MEMORANDUM

DATE: October 12, 2012

SUBJECT: Canal Plaza Hotel, Site Plan Review

DeLuca-Hoffman Associates, Inc. has reviewed the Final Level III Site Plan Application for the Canal Plaza Hotel located at the corner of Fore and Union Streets. The project consists of constructing a 123 unit select service hotel, restaurant and retail space. The project is a conversion of an existing parking lot area into building space.

EXHIBIT-04

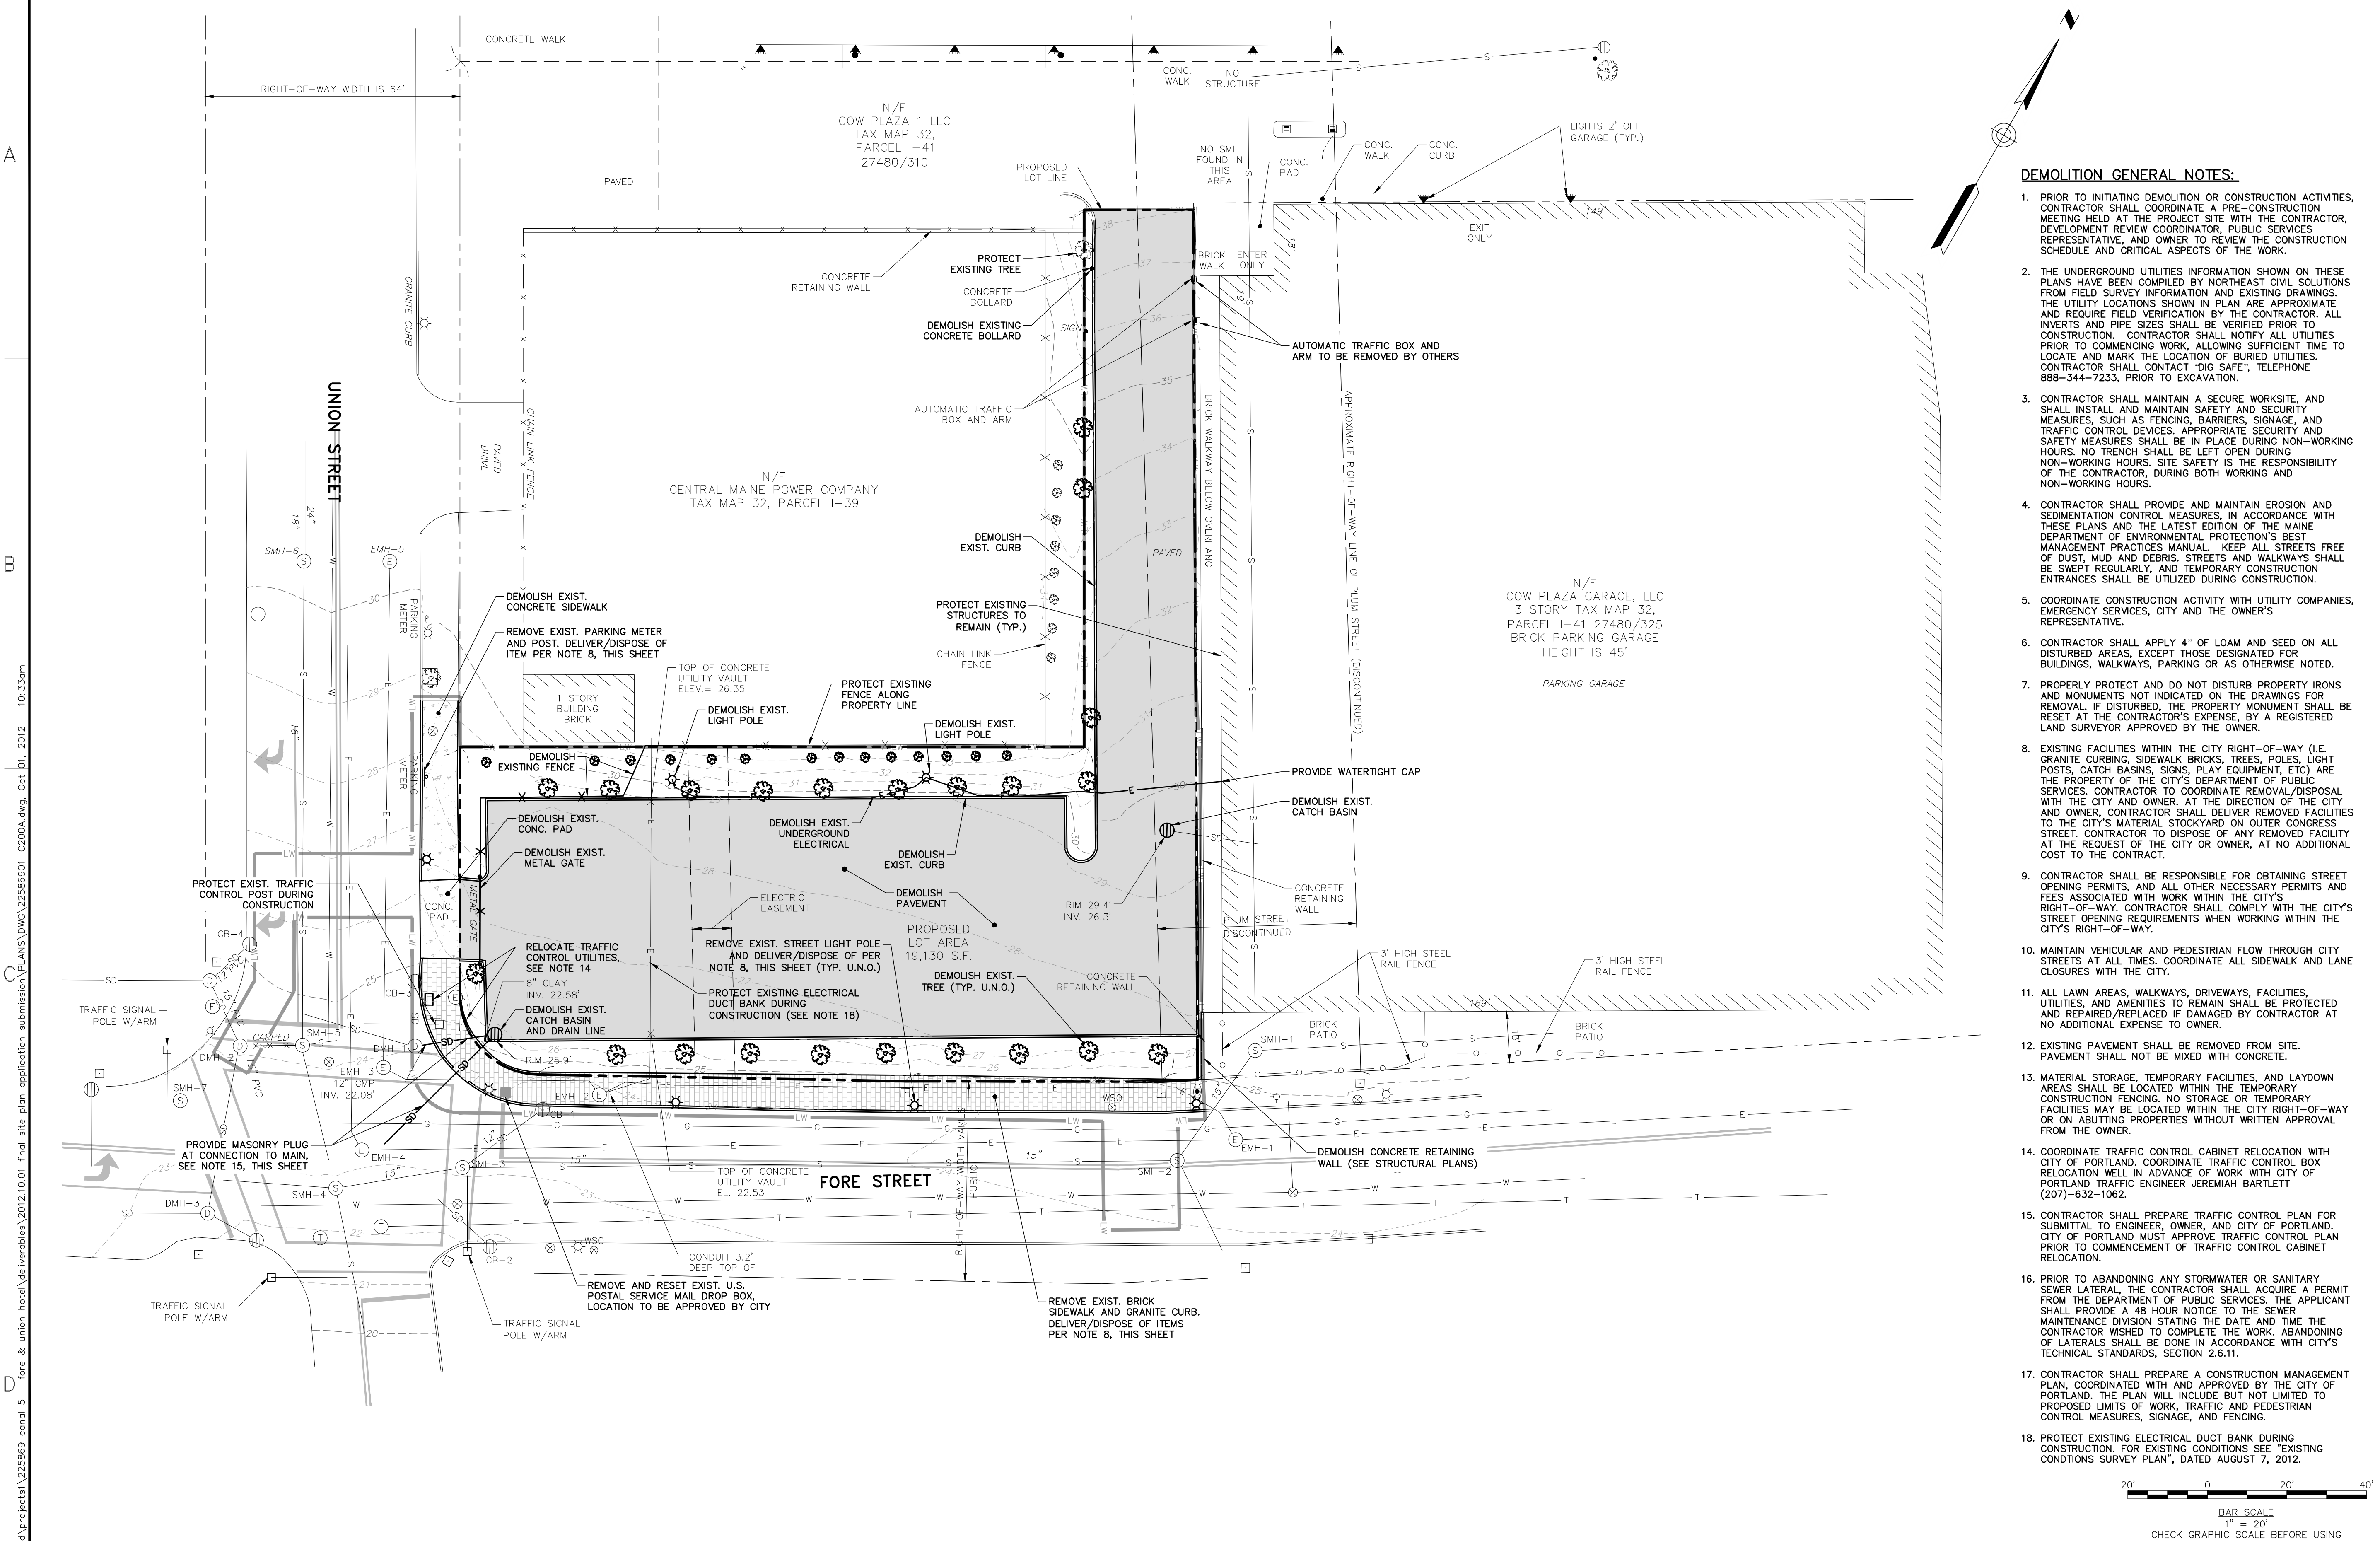
1. We note that demolition and excavation work is likely to extend onto the adjacent CMP property. It may be necessary to obtain a temporary construction easement for these purposes. We understand the applicant owns the adjacent parking garage building, so no construction easement is necessary, unless a new developer/owner takes over the project following approvals.

C-201

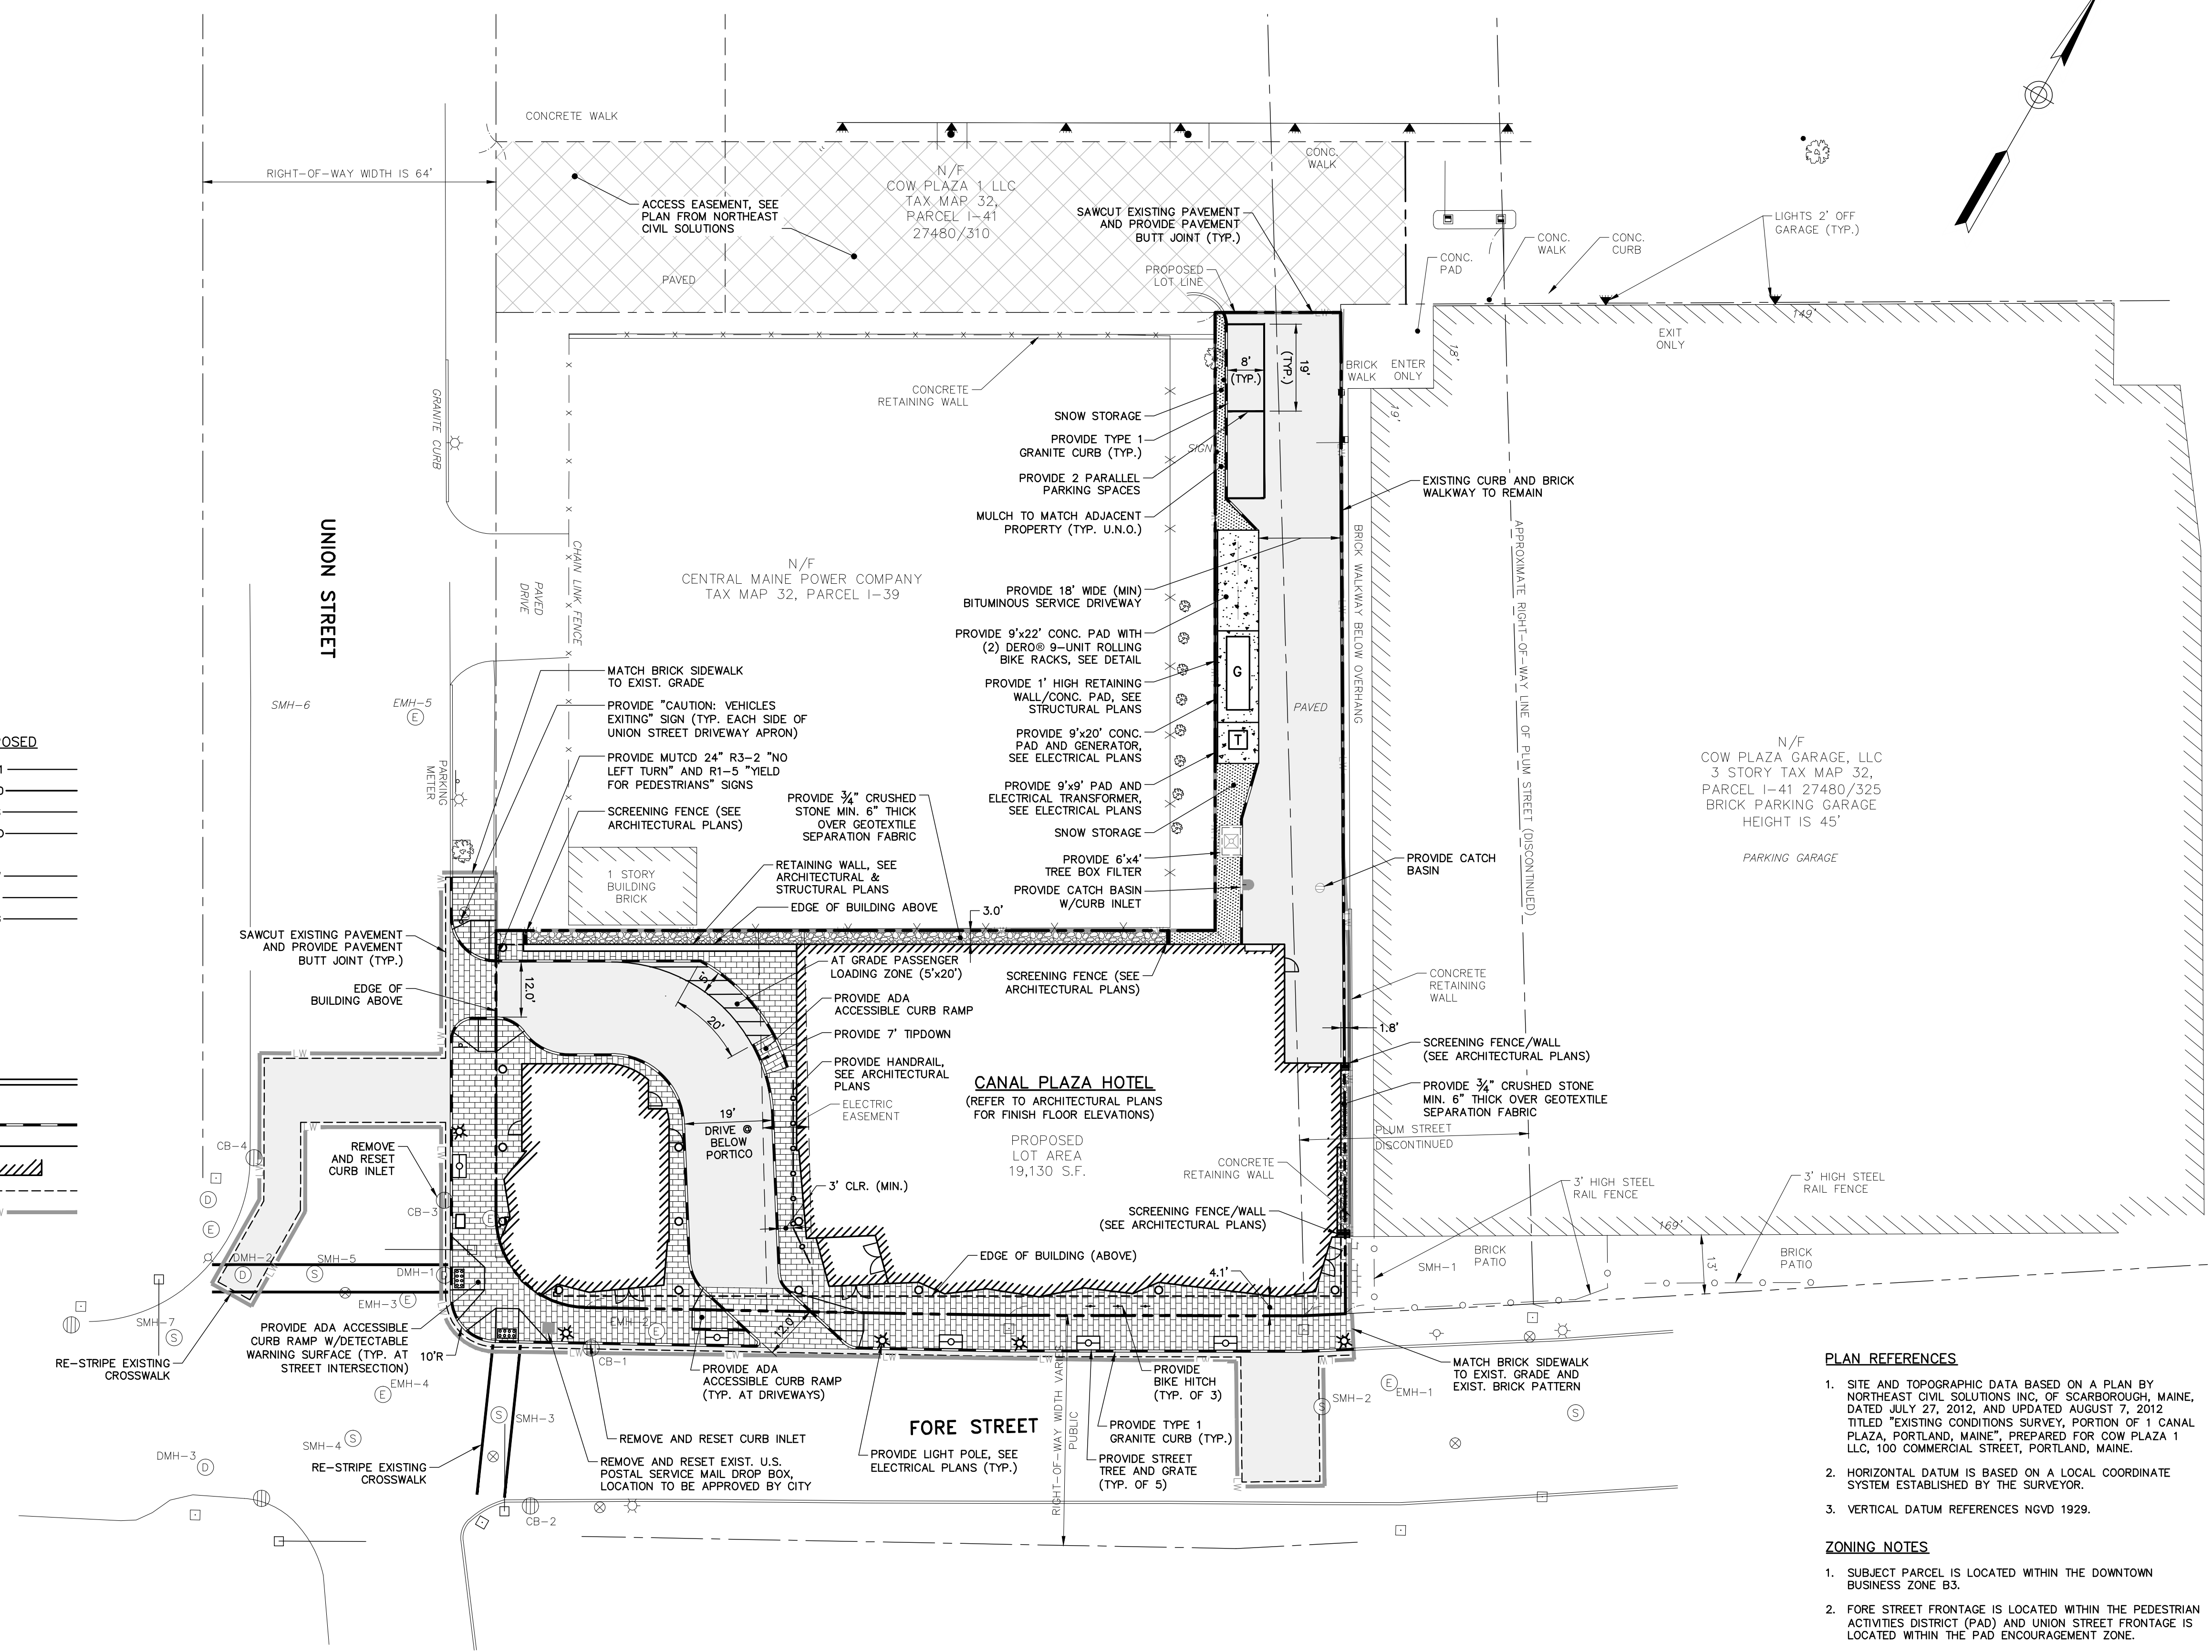
1. The plan indicates a 9' x 9' transformer pad which is placed directly adjacent the property boundary. Evidence of CMP's acceptance of this placement should be provided. CMP owns the adjacent parcel so this is likely OK, however this should be confirmed.
2. Does the City require the horizontal datum be tied to the City's coordinate system?
3. Are "Do Not Enter" signs necessary at the Union Street exit driveway?

4. We recommend that Structural soil mix be considered for the tree areas within the sidewalk zones. Perhaps Jeff Tarling can weigh in on the use of this material and if it would be beneficial.
